**CITY OF PORTLAND, MAINE**  
**PLANNING BOARD**

September 26, 2007

RE: University of Southern Maine- University Commons  
CBL: 114-A-004  
Application ID: #2006-0150

**OSHER MAP LIBRARY &  
 THE GLICKMAN FAMILY LIBRARY**  
 FOREST AVENUE ELEVATION

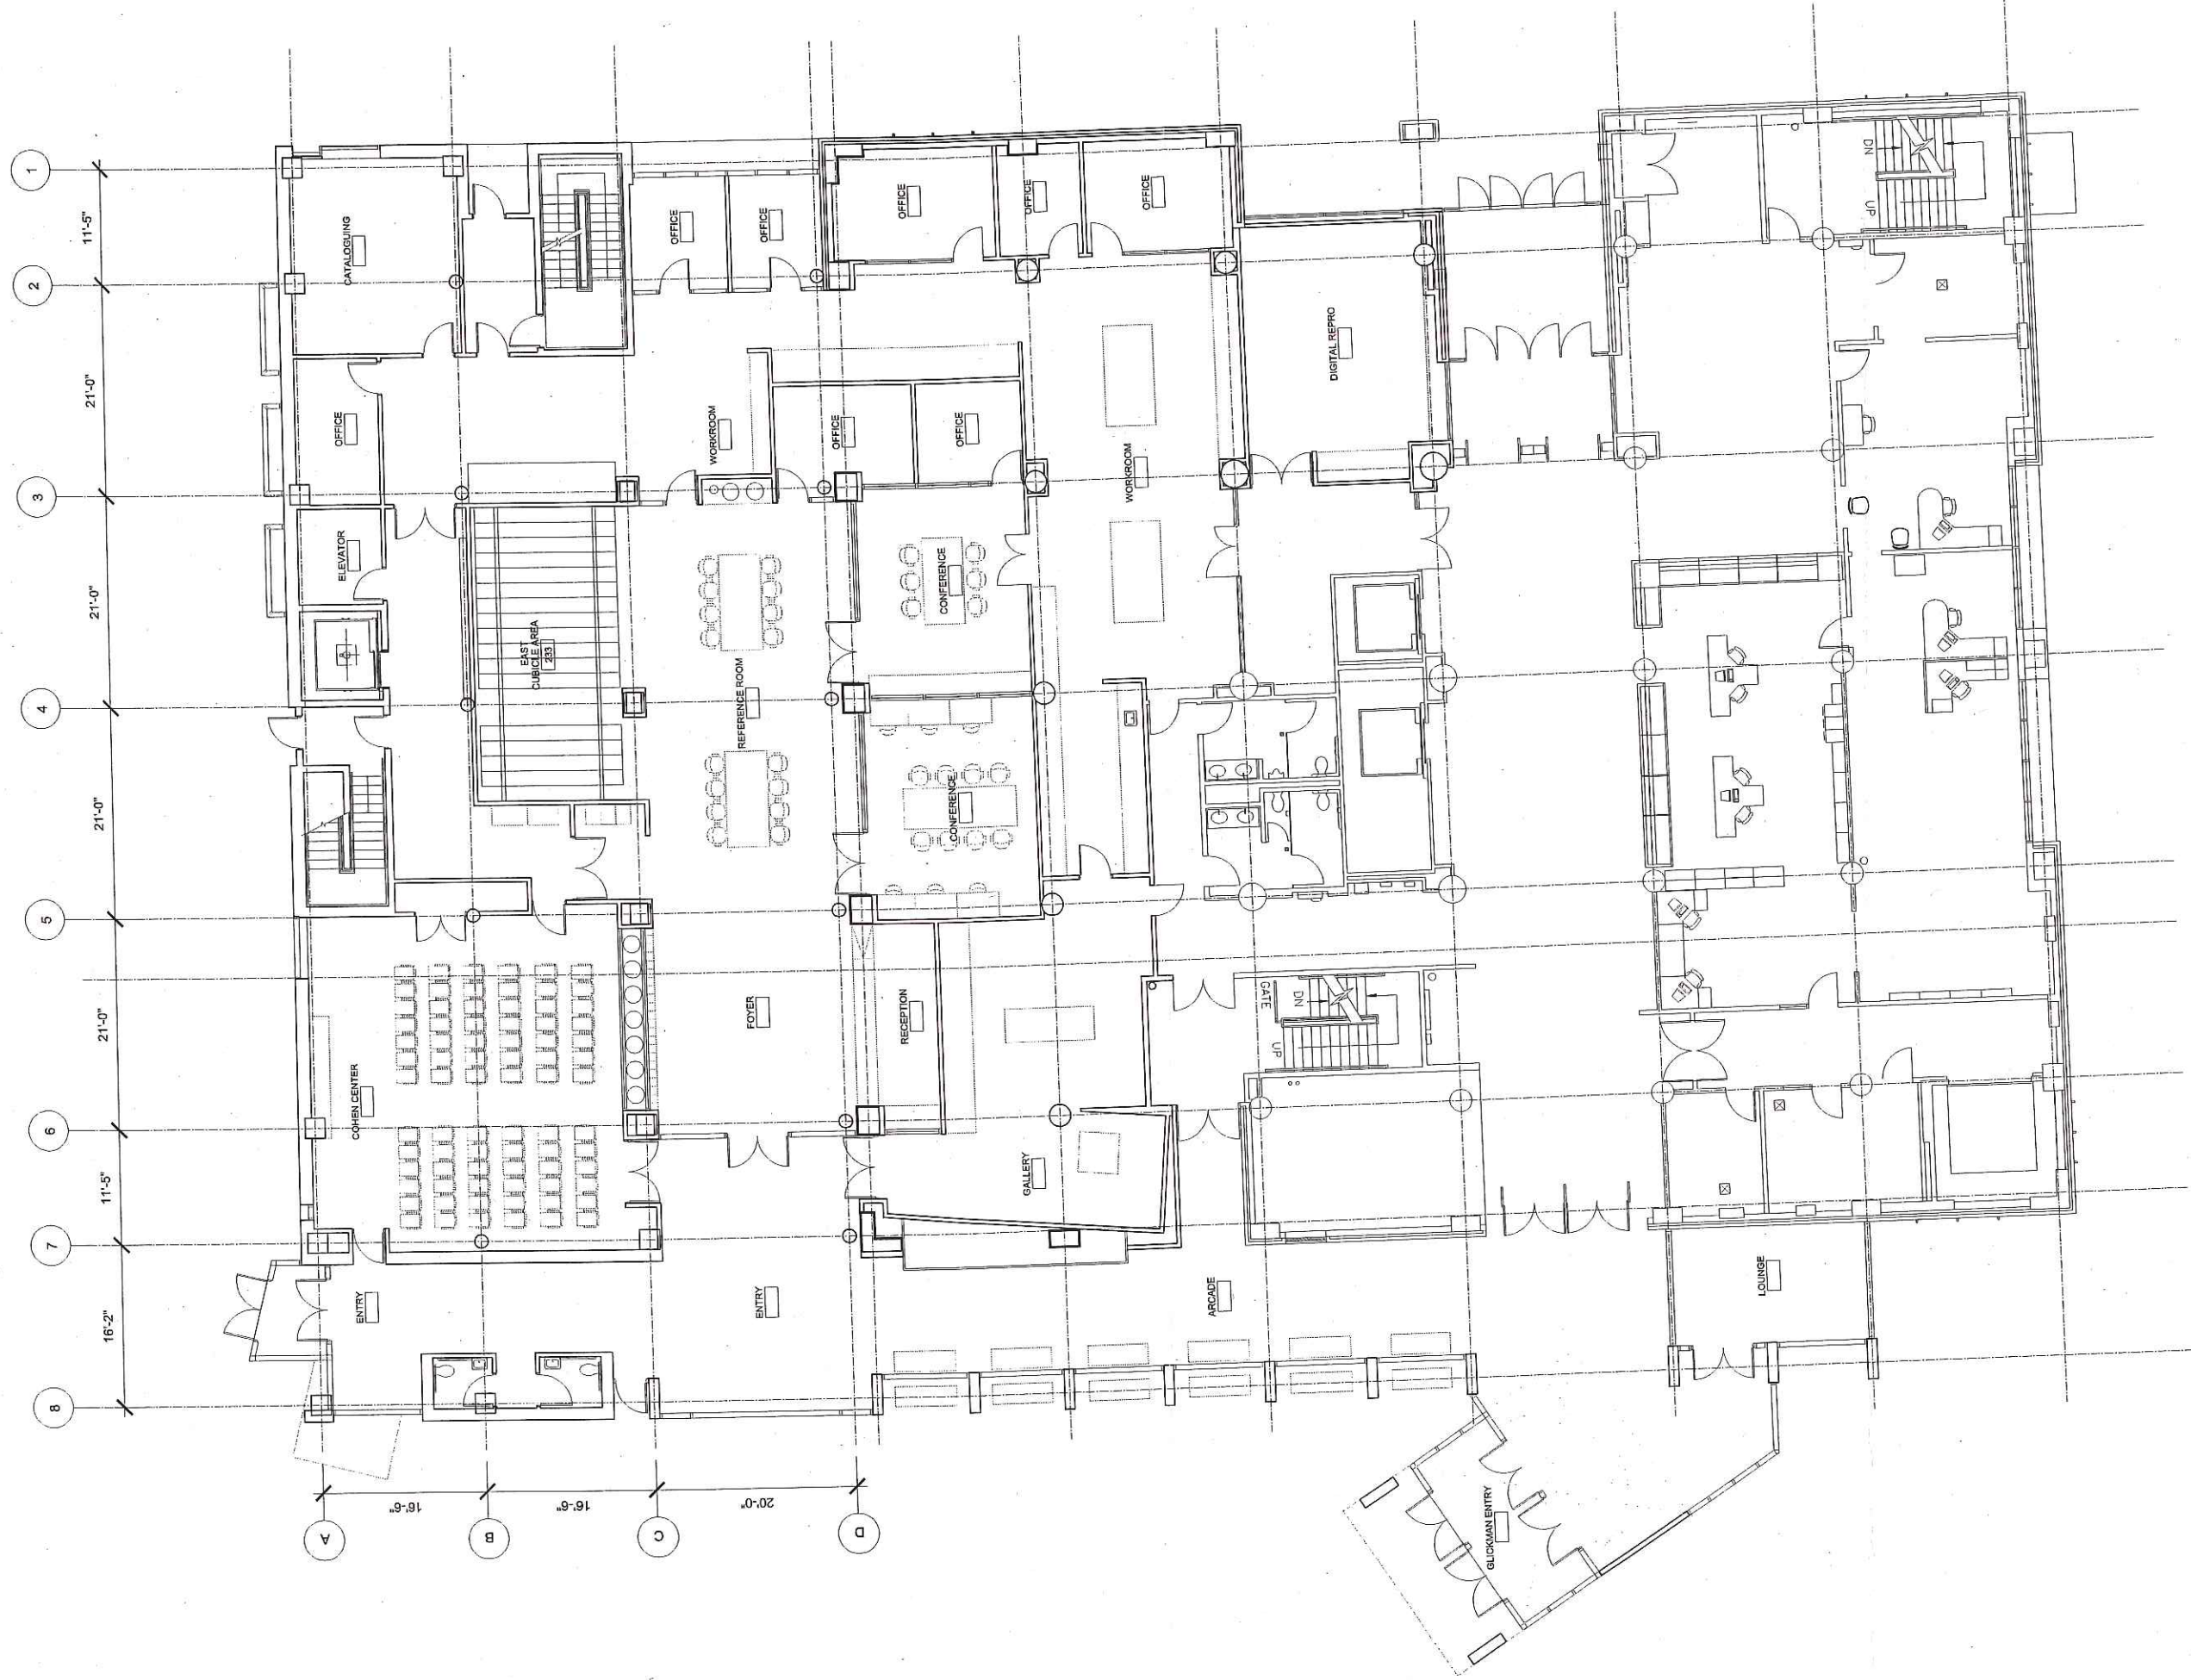
1. That the proposed revision for the egress door facing Forest Avenue meets the conditions of approval number nine (9) imposed by the Planning Board on March 13, 2007.
2. Amend condition number ten (10) of the original site plan approval to state:
